# **Sheringham Shoal and Dudgeon Offshore Wind Farm Extension Projects**

Traffic and Transport Discussions with  
Norfolk County Council

Title:	
<b>Sheringham Shoal and Dudgeon Offshore Wind Farm Extension Projects Examination submission Traffic and Transport Discussions with NCC</b>	
PINS document no.:	
Document no.:	
Date:	Classification
<b>10.01.2023</b>	<b>Draft</b>
Prepared by:	
<b>Royal HaskoningDHV</b>	
Approved by:	Date:
<b>Sarah Chandler, Equinor</b>	<b>XX</b>

**Table 1-1 NCC Comments on SEP and DEP DCO documents and the Applicant's response**

605000 610000 615000 620000 625000

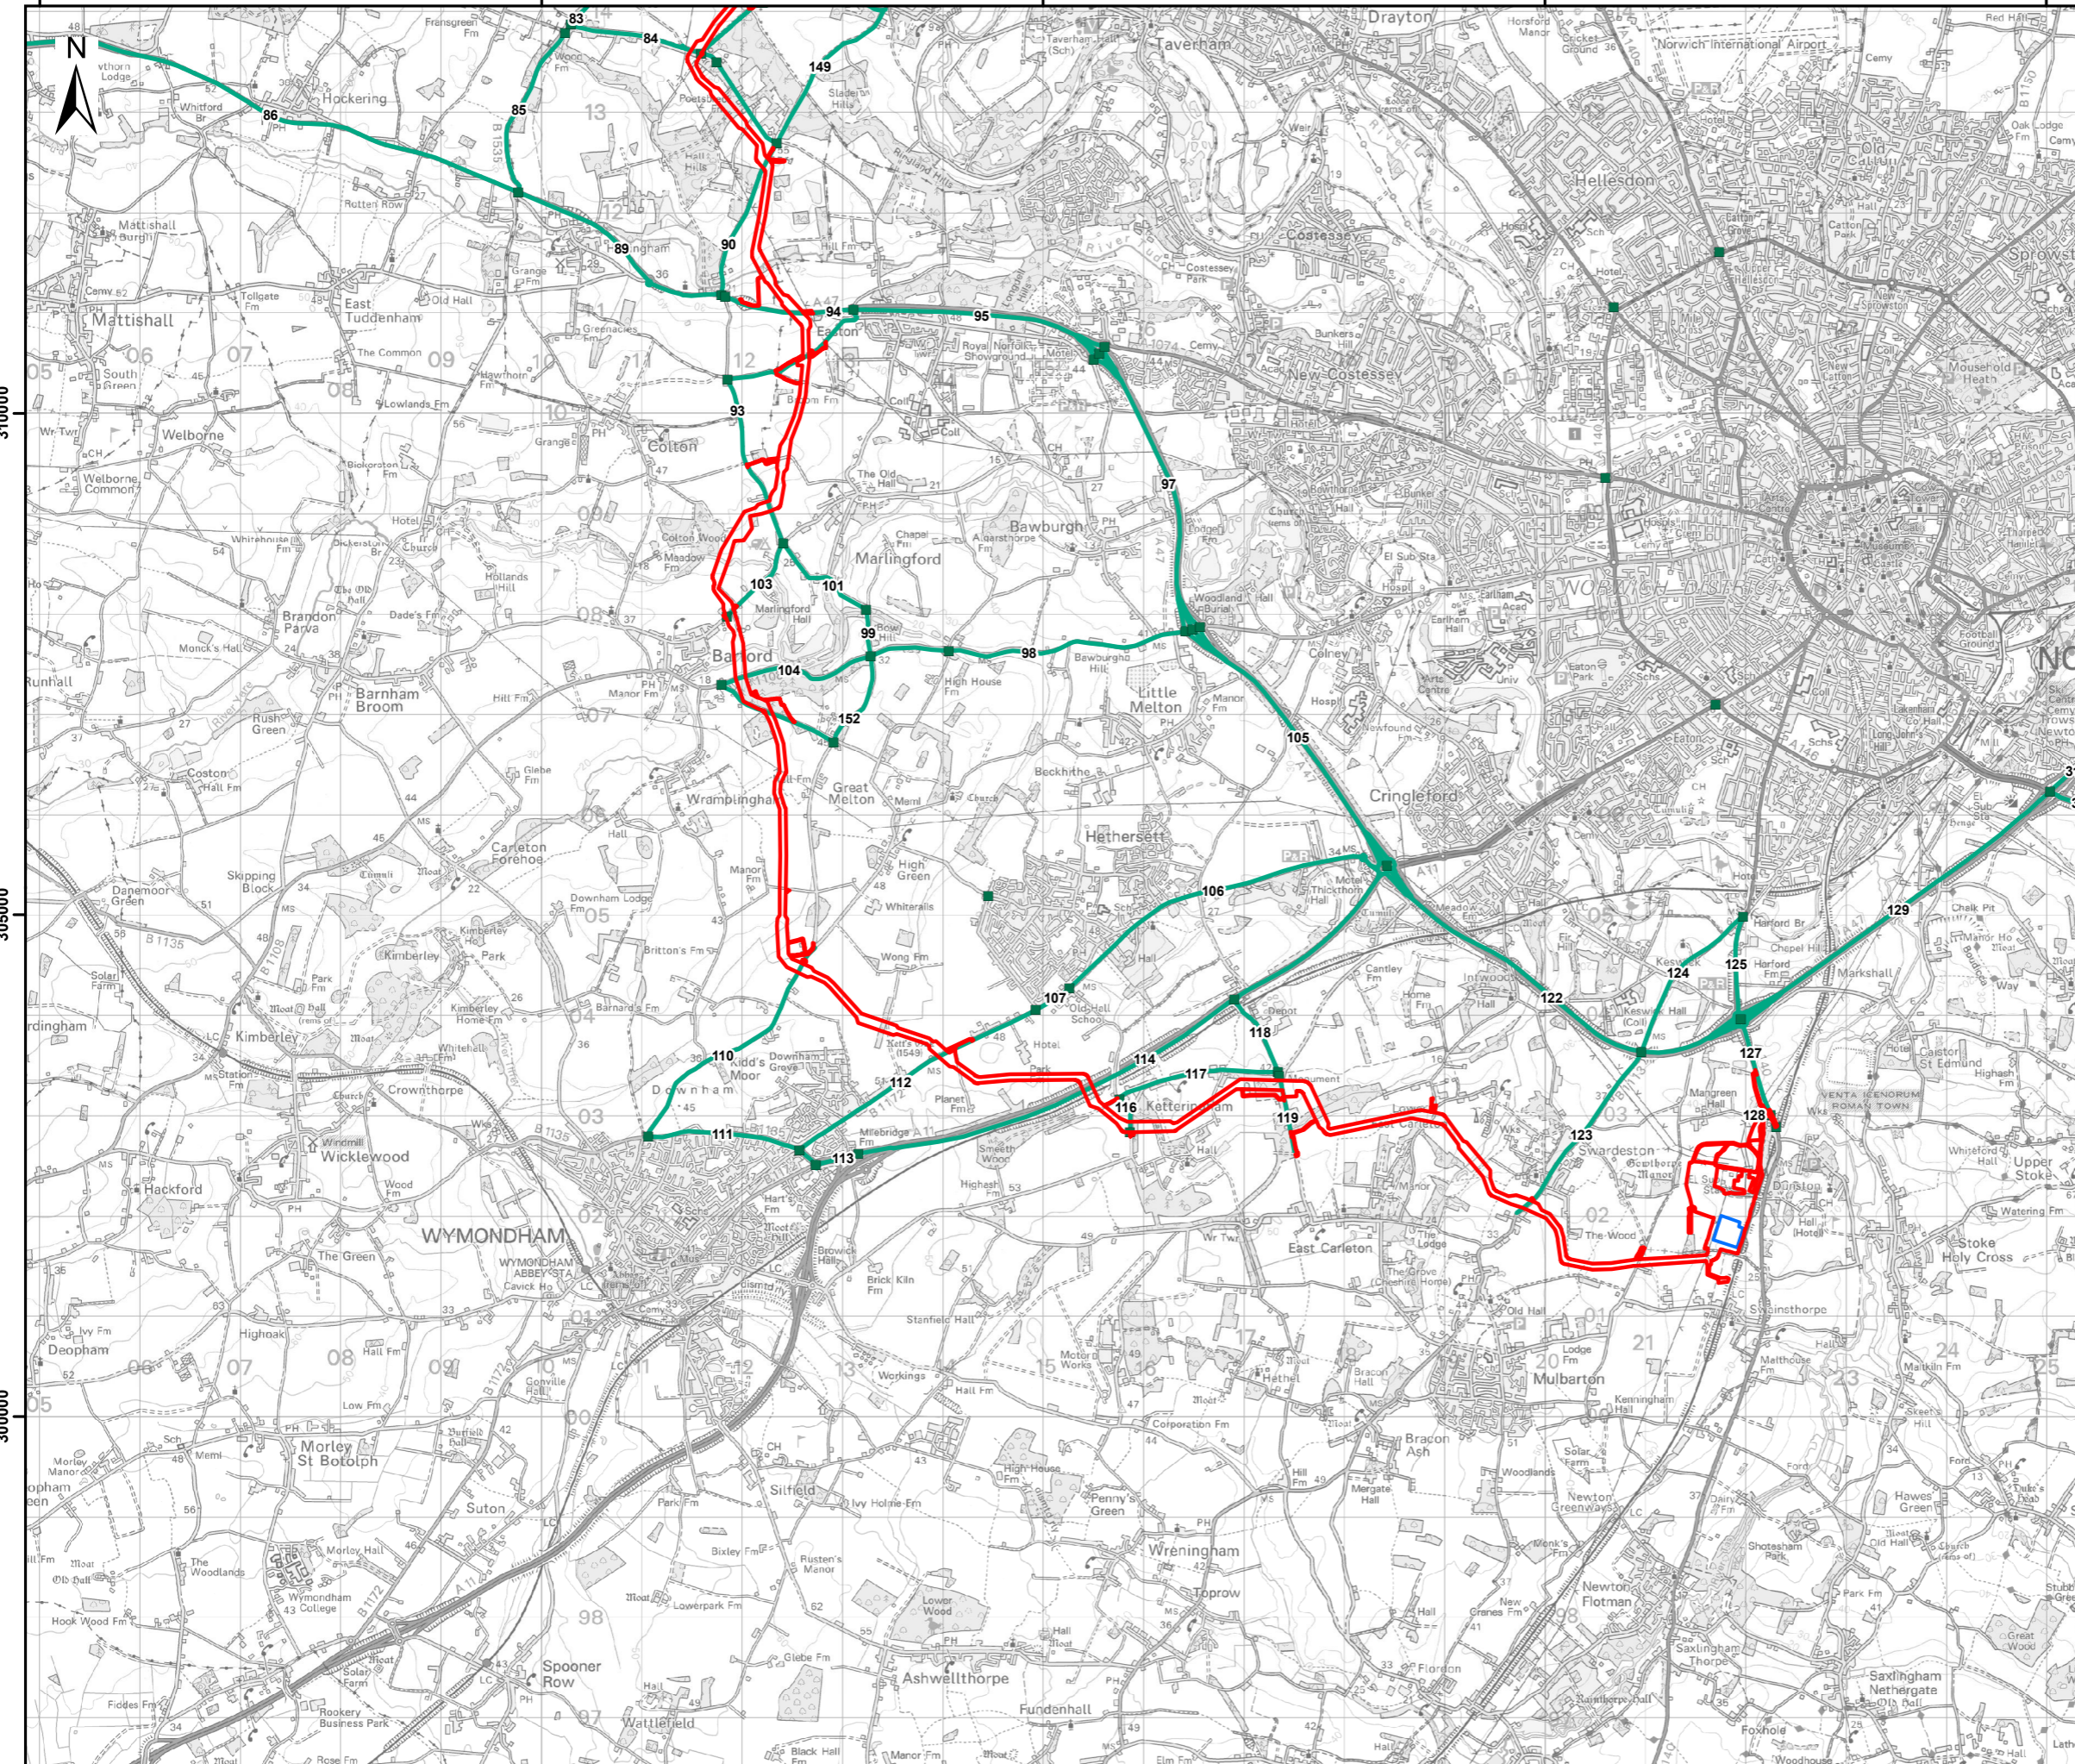
I.D.	NCC identified document, page, section number, etc.	NCC Comment	Applicant Response	Record of discussions with NCC
			<p>identified above. Section 2.3 of the OCTMP sets out how the routing of HGVs will be controlled.</p> <p>The Applicant however wishes to highlight an error with Figure 1 of the OCTMP [APP-301] which incorrectly shows HGVs being permitted through Weston Longville. The Applicant can confirm that this error will be corrected in a revision to the OCTMP and that no HGV traffic will be permitted to route via Weston Longville.</p>	
13	The [O]CTMP - para 32	Link 133 has a tight bend over a bridge and the crossroads/Link 150 are a nightmare in the peak times though not necessarily a reason to avoid. You need to demonstrate its suitability for use by HGV's	<p>Table 24-20 of Chapter 24 of the ES [APP-110] sets out SEP and DEP could result in a peak increase in all vehicles and HGV traffic via link 133 of 5% and 17% respectively.</p> <p>It can be identified from Table 24-48 of the Chapter 24 of the ES [APP-110] that due to the width of link 133, mitigation measures will be required to accommodate the forecast increase in HGV traffic.</p> <p>The measures outlined in Table 24-48 are captured within section 4.4 the OCTMP [APP-301] which is secured via Requirement 15 of the draft DCO [APP-024].</p> <p>Section 4.4 of the OCTMP outlines a range of measures, to manage the passage of SEP and/or DEP traffic along narrow roads, including:</p> <ul style="list-style-type: none"> <li>• Road/ junction widening;</li> <li>• Formalising existing informal passing places; or</li> <li>• Using mobile traffic management, such as: <ul style="list-style-type: none"> <li>• An escort vehicle to guide HGVs along roads and past oncoming traffic;</li> </ul> </li> </ul>	NCC confirmed that they are content with the clarification provided and that the measures outlined within the OCTMP to manage traffic movements are appropriate.
